Subject: Rucker Boundary Line Adjustment (BL-15-00005)

BOUNDARY LINE ADJUSTMENT BL-15-00005
 PREPARED FOR
MANORD RUCKER
 A PORTION OF THE SOUTHEAST 1/4 AND THE SOUTHWEST 1/4 OF SECTION 30,
 TOWNSHIP 20 NORTH, RANGE 17 EAST, W.M.
 KITTITAS COUNTY WASHINGTON

PREPARED FOR
MANORD RUCKER
A PORTION OF THE SOUTHEAST QUARTER OF SECTION 30,
TOWNSHIP 20 NORTH, RANGE 17 EAST, W.M.
KITITAS COUNTY WASHINGTON
DWN BY DATE JOB NO.
DLP 6/2015 15030
CHKD BY SCALE SHEET
GW 1" = 100' 1 OF 3

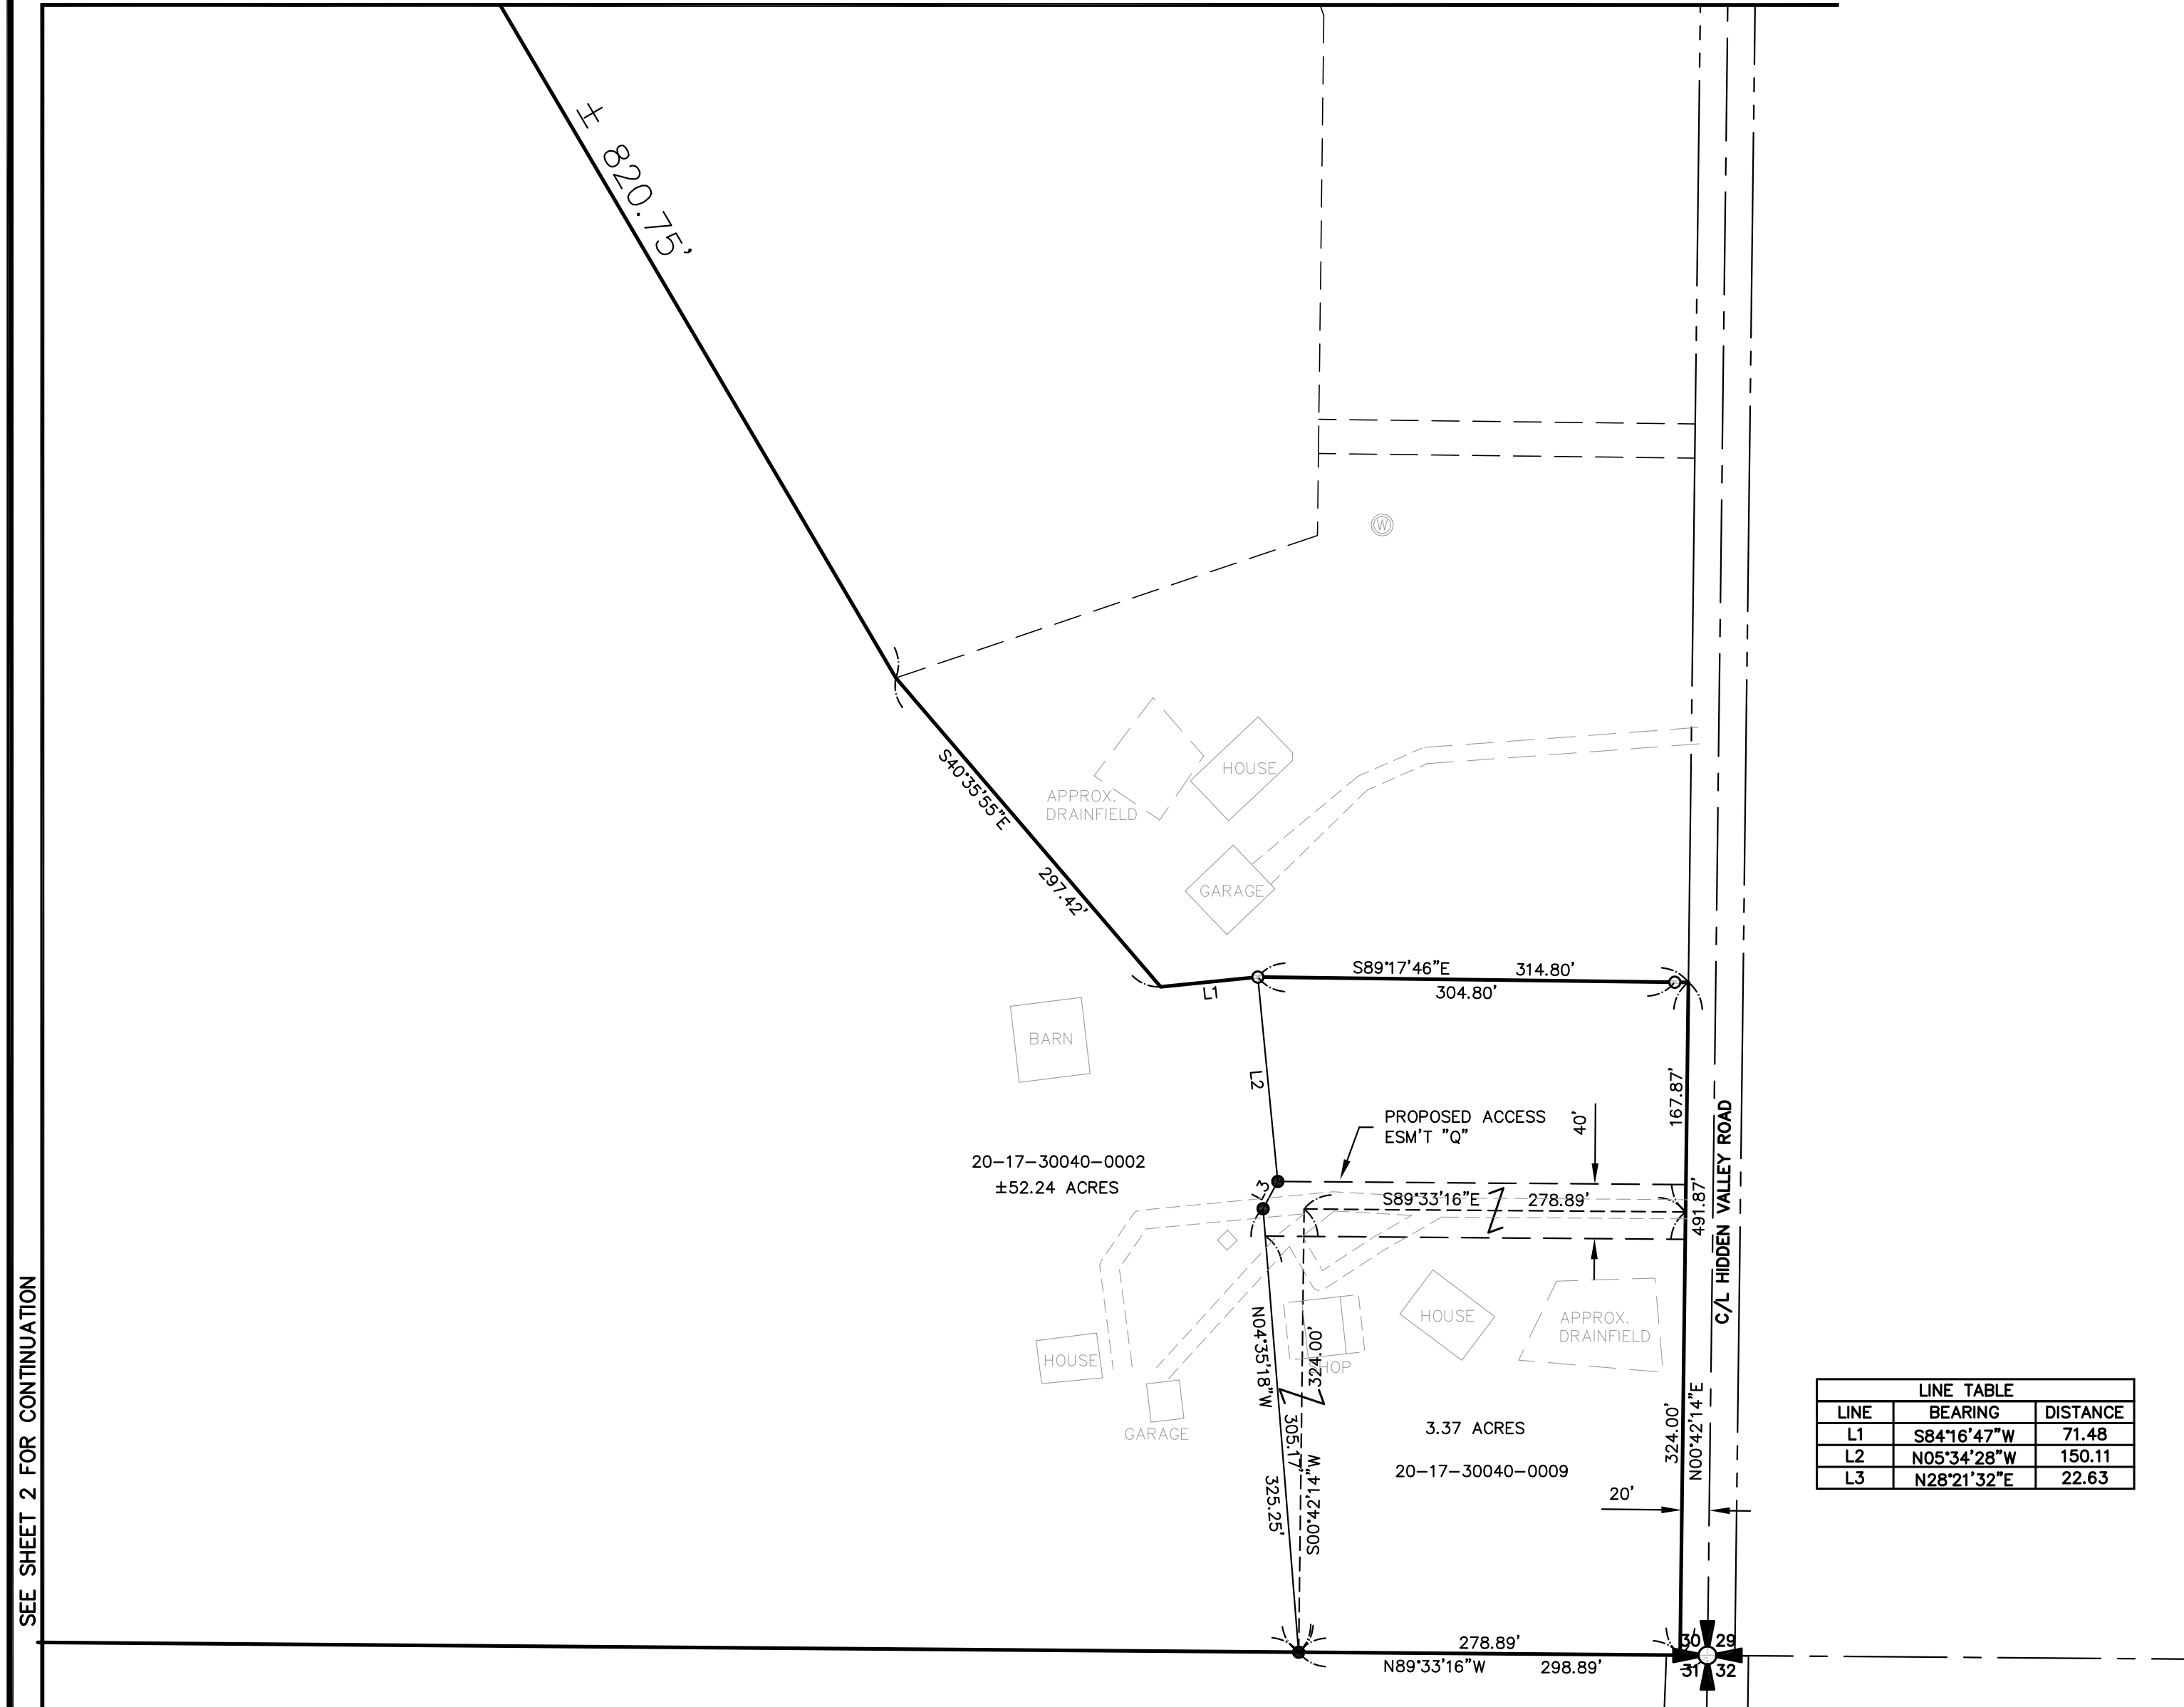
- ***Public Health will need measurements from the drainfield to the new property line and the location of the well serving the water system. For further questions regarding this additional information please contact Kittitas County Public Health 509-962-7515.***

**RECORD OF SURVEY**  
 A PORTION OF THE SE 1/4 OF SECTION 30,  
 TOWNSHIP 20 NORTH, RANGE 17 EAST, W.M.,  
 KITITAS COUNTY, WASHINGTON

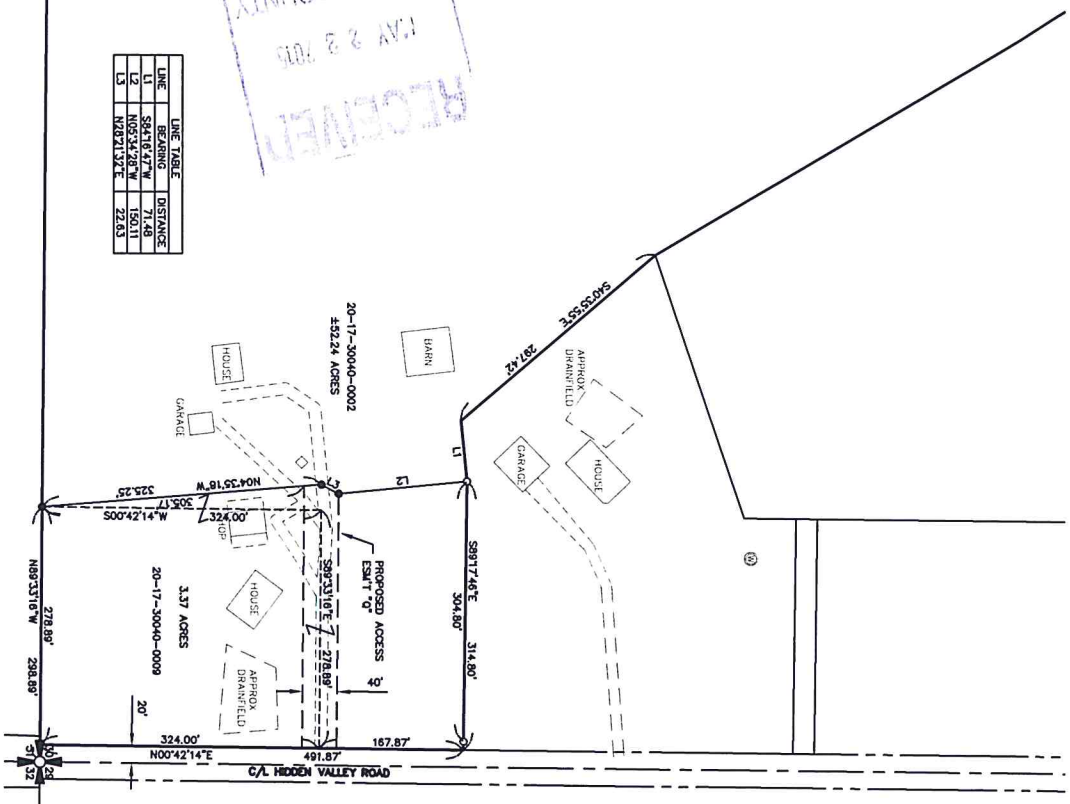
- *Scaled site plan encompassing all parcels involved in the boundary line adjustment. You have submitted a site plan with all of parcel 20-17-30040-0009 and part of parcel 20-17-30040-0002.*
